From: Danielle Cooper
Sent: 24 November 2025 15:56
To: DC Admin
Subject: FW: Penistone Rd 2025/93108

From: Cllr Alison Munro <Alison.Munro@kirklees.gov.uk>
Sent: 19 November 2025 17:47
To: Danielle Cooper <Danielle.Cooper@kirklees.gov.uk>
Subject: FW: Penistone Rd

Drawing Title.
**SITE PLAN
VISIBILITY SPLAY**

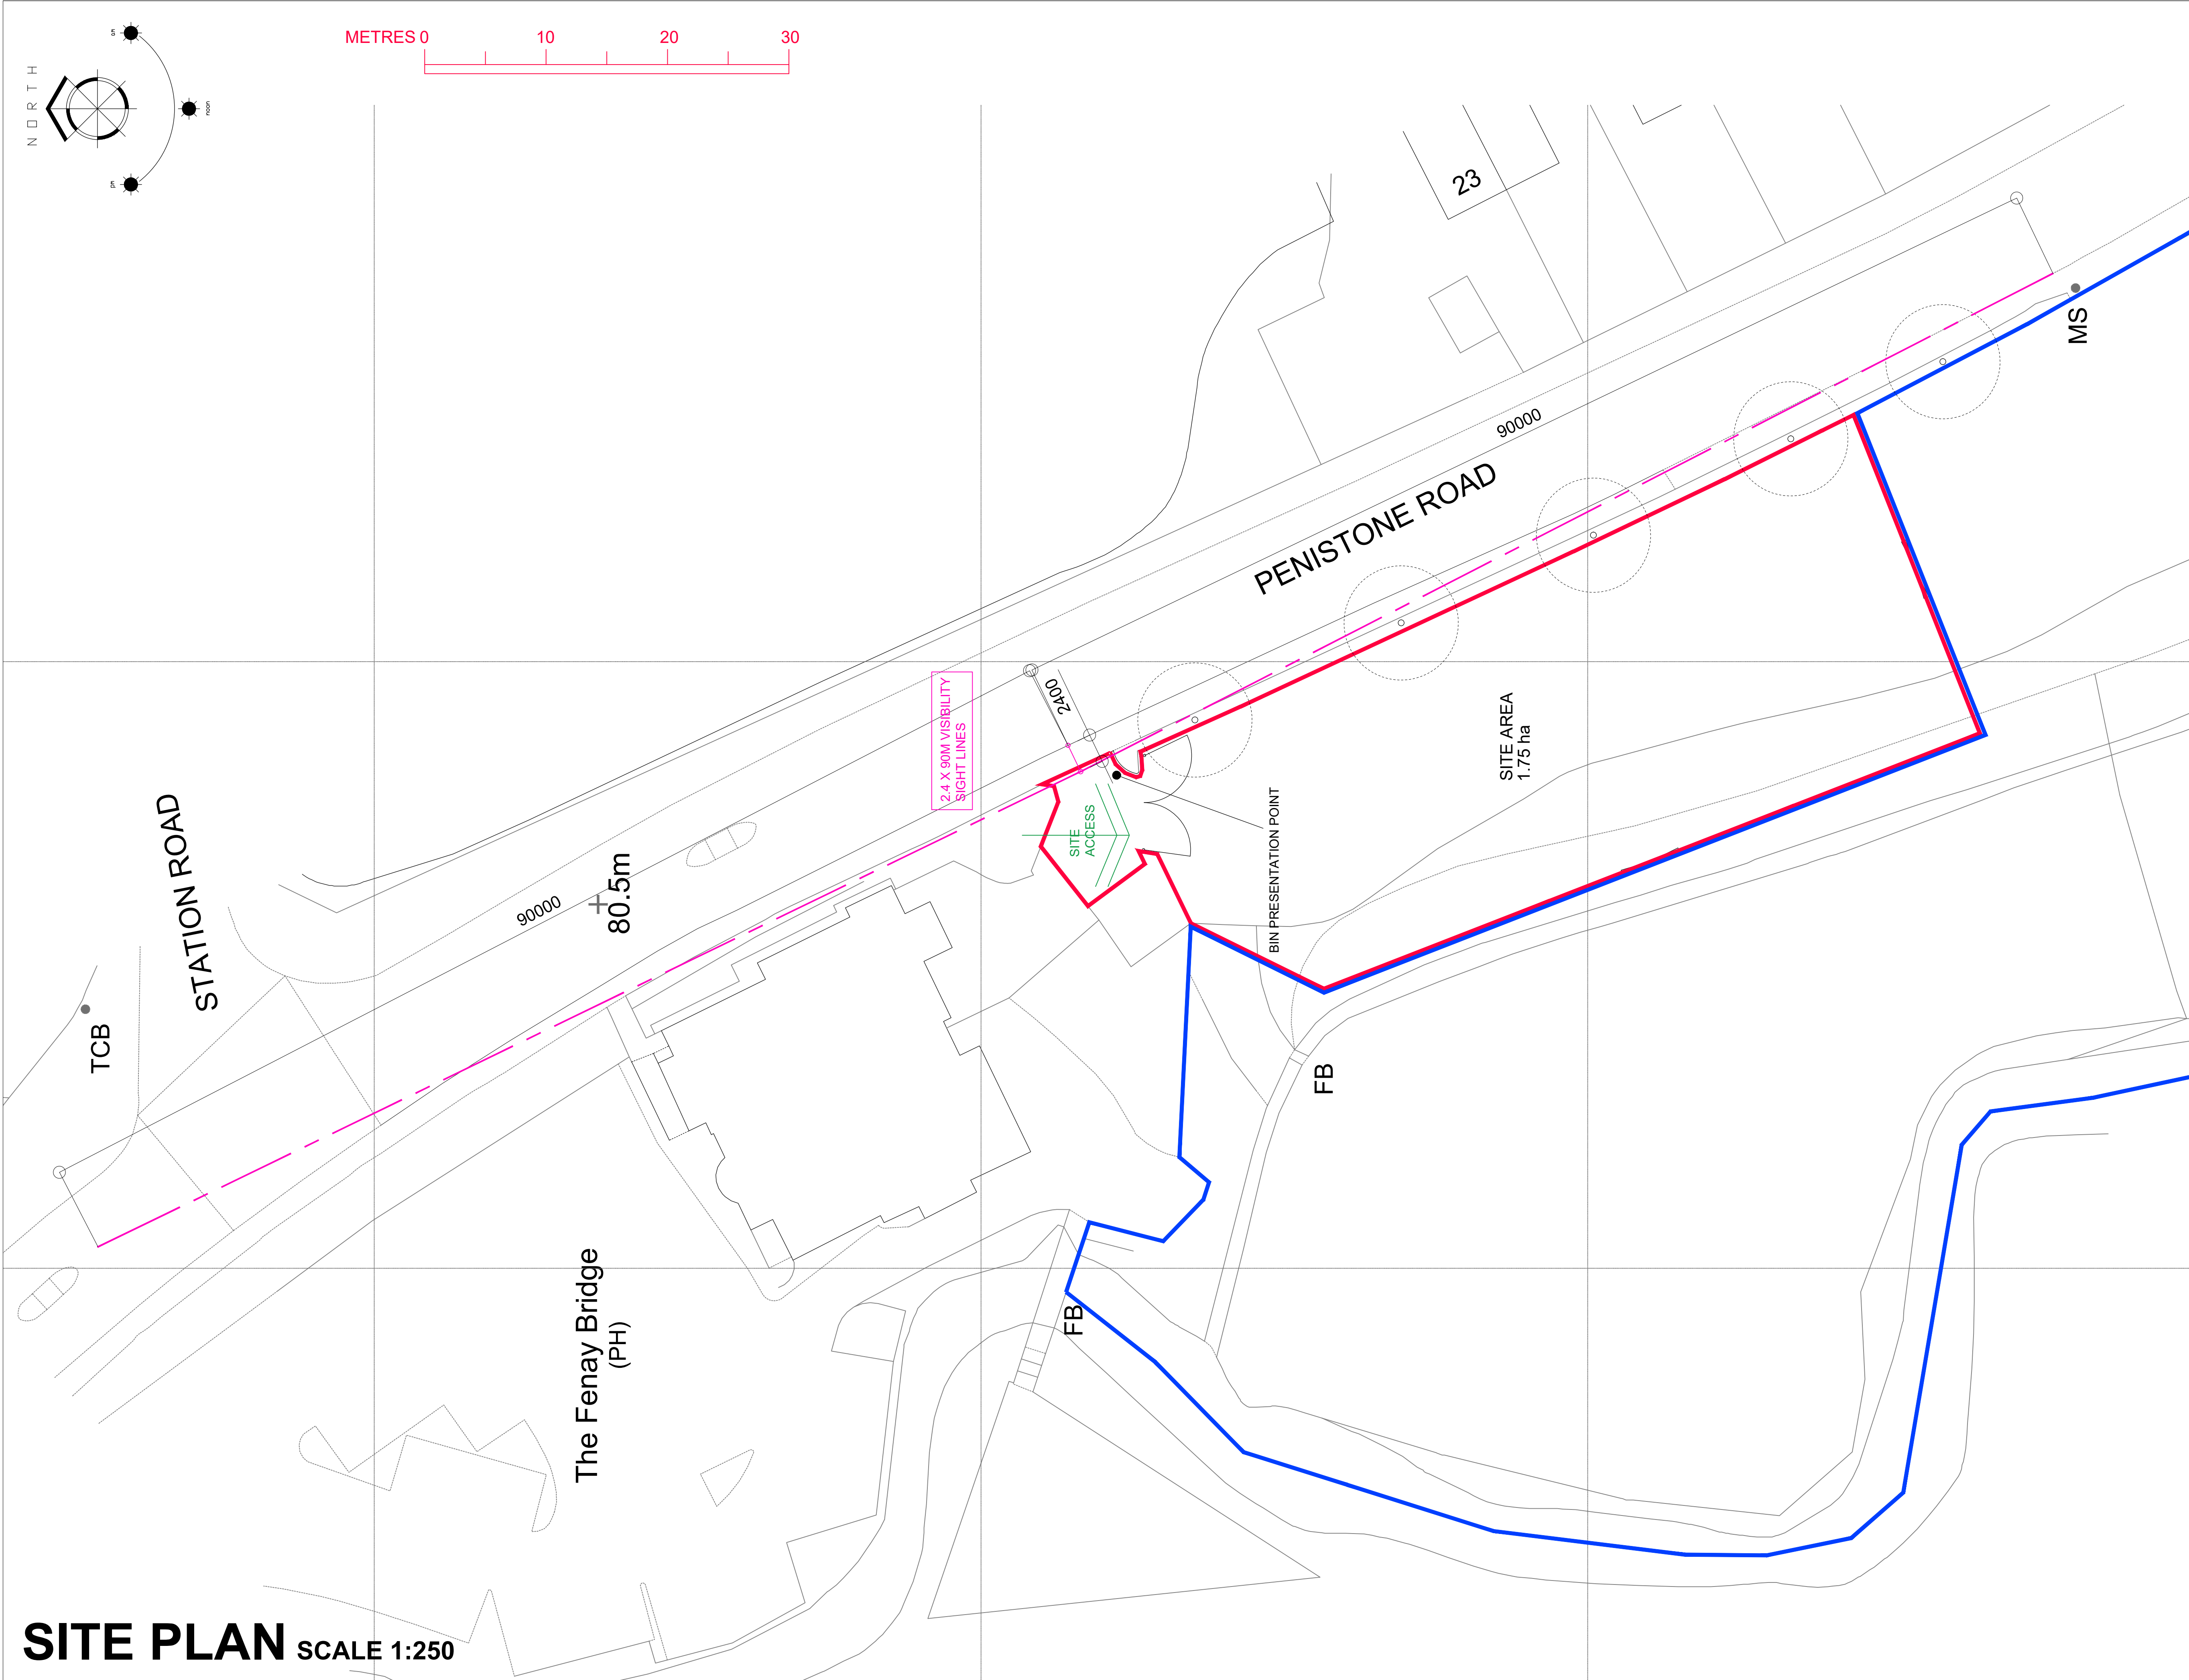
You will see trees are growing on the site albeit at the sides and rear. In addition the site is very close to the Beck and the proposed siting of the house which would be built towards the Beck would be even closer to the Beck, so this needs to be taken into consideration and measured as it may be at the limits of 20m or even within 20m.

The planning application says there are no trees on site and the site is not within 20 metres of a watercourse. This may not be true.

Its really difficult to understand why the house is being built at the far side of the site and I worry they will simply build more stables and keep their horses on the land as they have also acquired land below the piece shown on the Council map as well as the land at the rear of the proposed house.
